May 8, 2014

**Re: Tracts 1 & 3 East Central Gateway Plaza, 10201 Central Avenue NE,  
Traffic Circulation Layout  
Architect's Stamp dated 5-05-14 (K20-D061))**

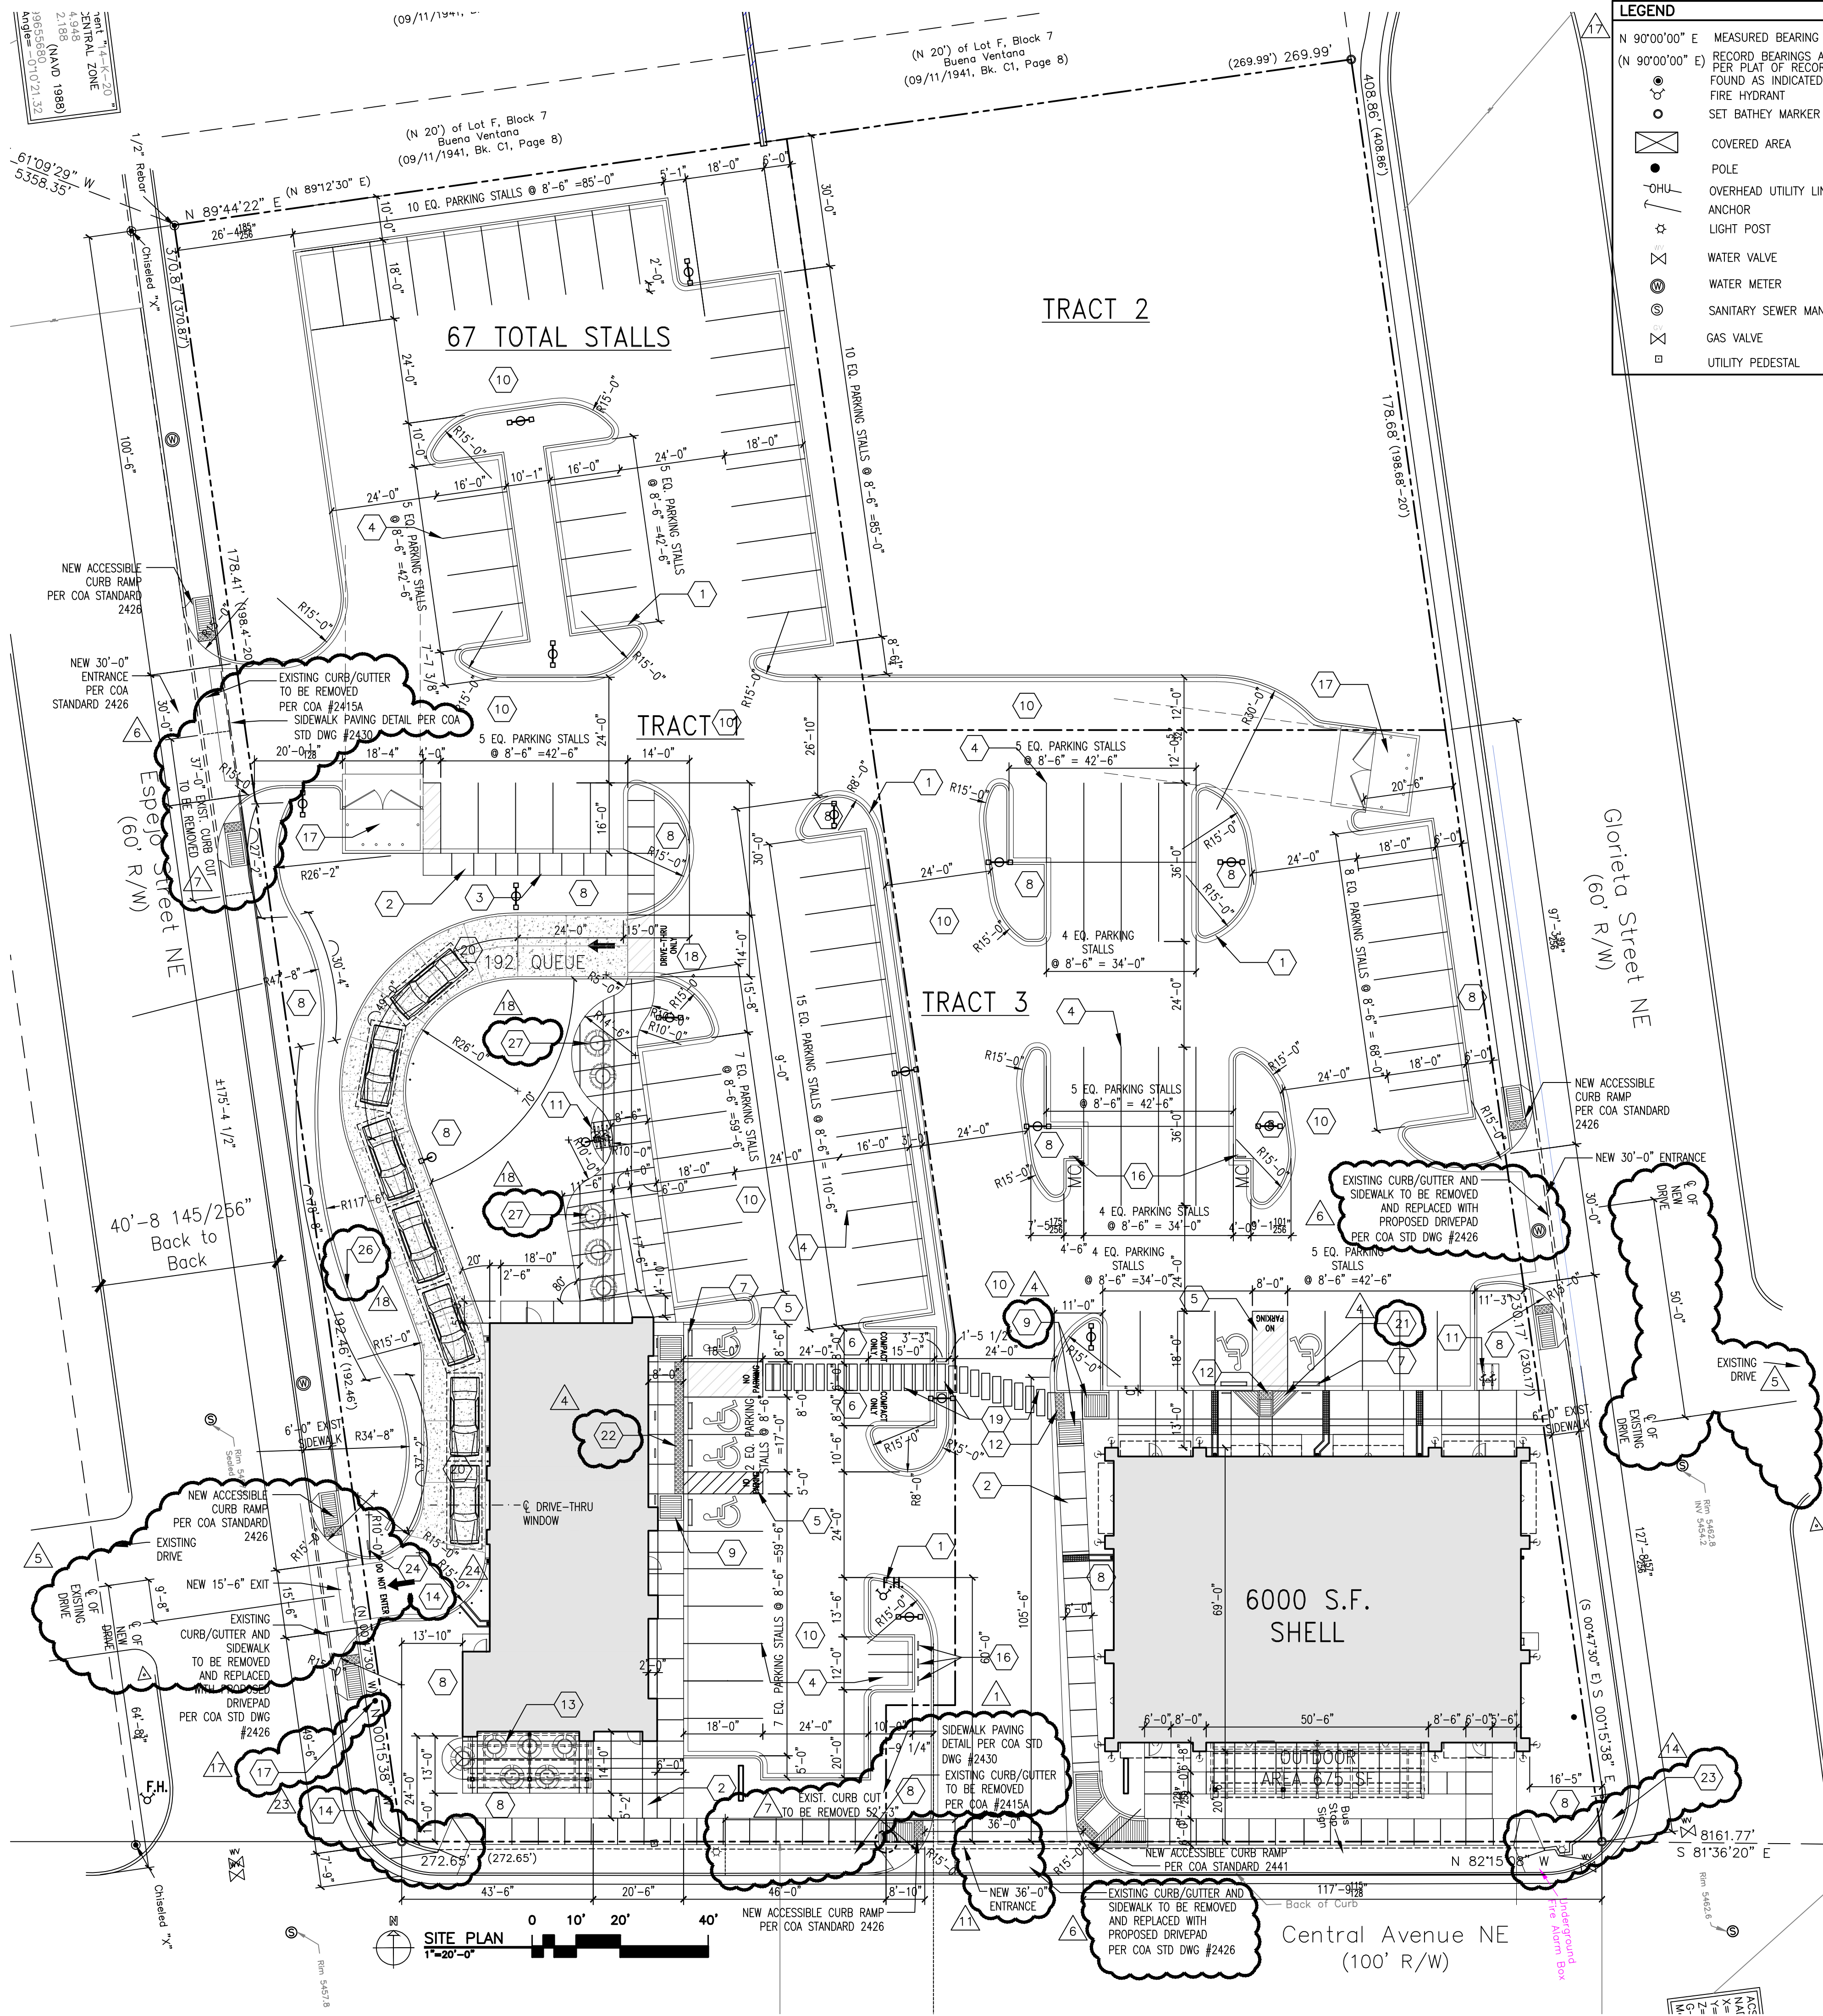
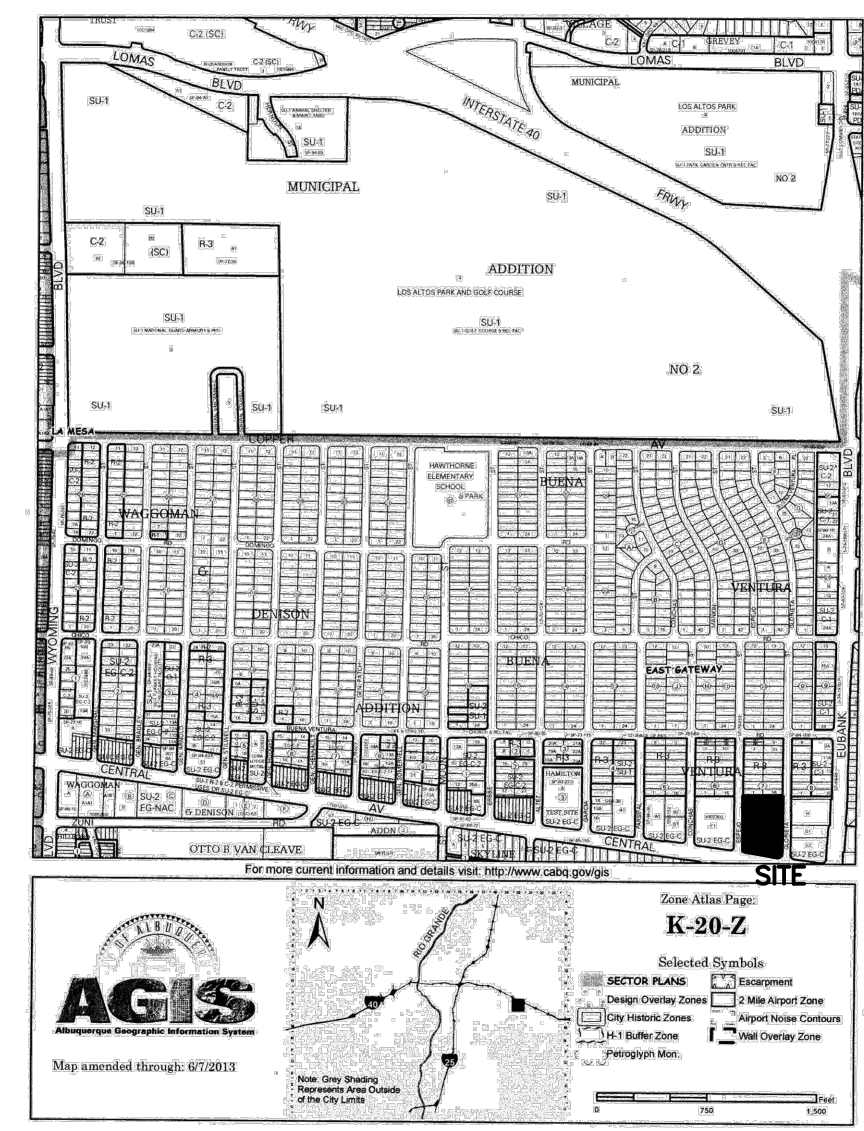
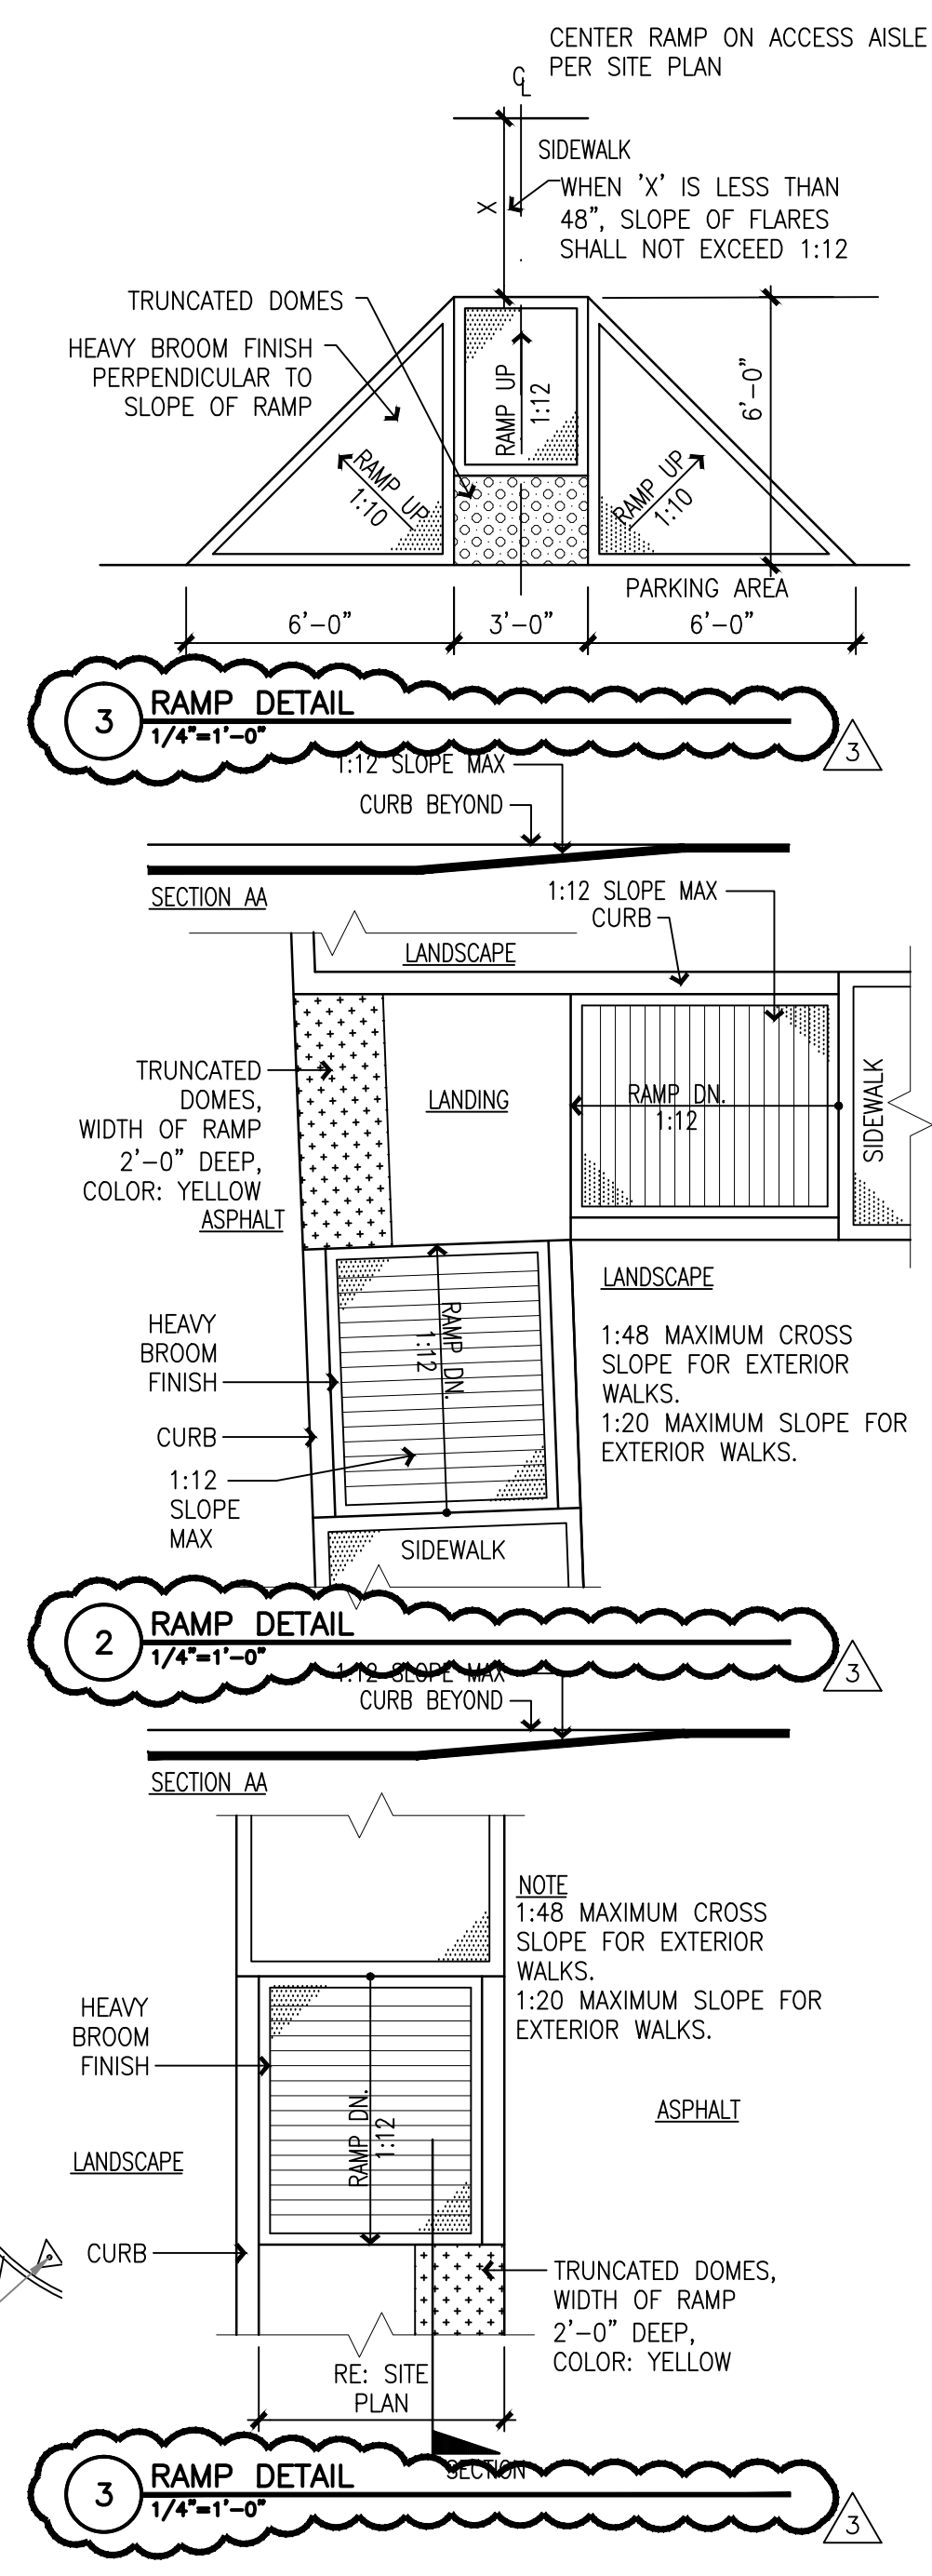
1. The development of this site must be in compliance with current DPM and ADA standards and regulations.
2. Please refer to all applicable city standards.

3. Please ensure all ramps are ADA compliant.
4. Show a detail of the wheelchair ramps located at the proposed interior crosswalks and HC Parking (key note 9), or refer to the appropriate city standard.

5. Please label and dimension all existing driveways across the street from proposed driveways. Please demonstrate proposed driveways meet DPM criteria for driveway placement (see the *Development Process Manual*, Chapter 23, Section 6, Part B.6). Where a drive exists on the opposite side of the street, the centerline of new drive needs to be within 15 ft of the existing drive centerline or offset 50 ft or more.

6. Clarify text on TCL "existing curb/gutter to be removed per COA #2415A." Should the text read "existing c&g and sidewalk to be removed and replaced with proposed driveway per COA Std Dwg #2426" ?

7. Abandon curb cuts must be replaced with sidewalk and curb & gutter. A build note must be provided referring to the appropriate City Standard (#2430 and #2415). Label/dimension driveways proposed to be removed.

8. Clarify the extents of the current phase. Executive Summary text refers to development on Tract 1&3 only; however, site plan indicates some infrastructure on Tract 2.

9. A cross-access agreement between Tract 3 & 2 will be required to allow current layout, allowing refuse pickup servicing Tract 3 to encroach into Tract 2.

10. Please provide evidence of Replat to identify 3 lots, Tract 1, 2, &3.  
Currently, AGIS indicates two lots, E & F.
11. Since Central Ave is an arterial roadway, driveways with full access (right in / right out and left in / left out); the drivepad has a 36-foot minimum width (40 ft desirable) (see the *Development Process Manual*, Chapter 23, Section 6, Part B.8).

14. Please indicate whether the sidewalk corner intersections have existing ADA accessible ramps ( Espejo/Central & Glorieta/Central).
15. All COA ROW curb & gutter, sidewalks, ramps, and drivepads must be in good condition and ADA accessible if applicable. Existing broken or cracked concrete infrastructure must be removed and replace to the nearest joint.

16. One-way vehicular paths require pavement directional signage and a posted "Do Not Enter" sign at the point of egress.
17. There appears to be a power pole south of the drive-thru exit. If so, is there an issue with clear sight requirements? Please label all power poles, guy wires, fire hydrants, etc, on site plan.

18. Label and detail all line types: within the perimeter of the drive-thru lane there appears to be patio tables to the east and an buffer wall to the west, no label provided.

19. Please add the following note: "Landscaping and signing will not interfere with clear sight requirements. Therefore, signs, walls, trees, and shrubbery between 3 and 8 feet tall (as measured from the gutter pan) will not be acceptable in this area."
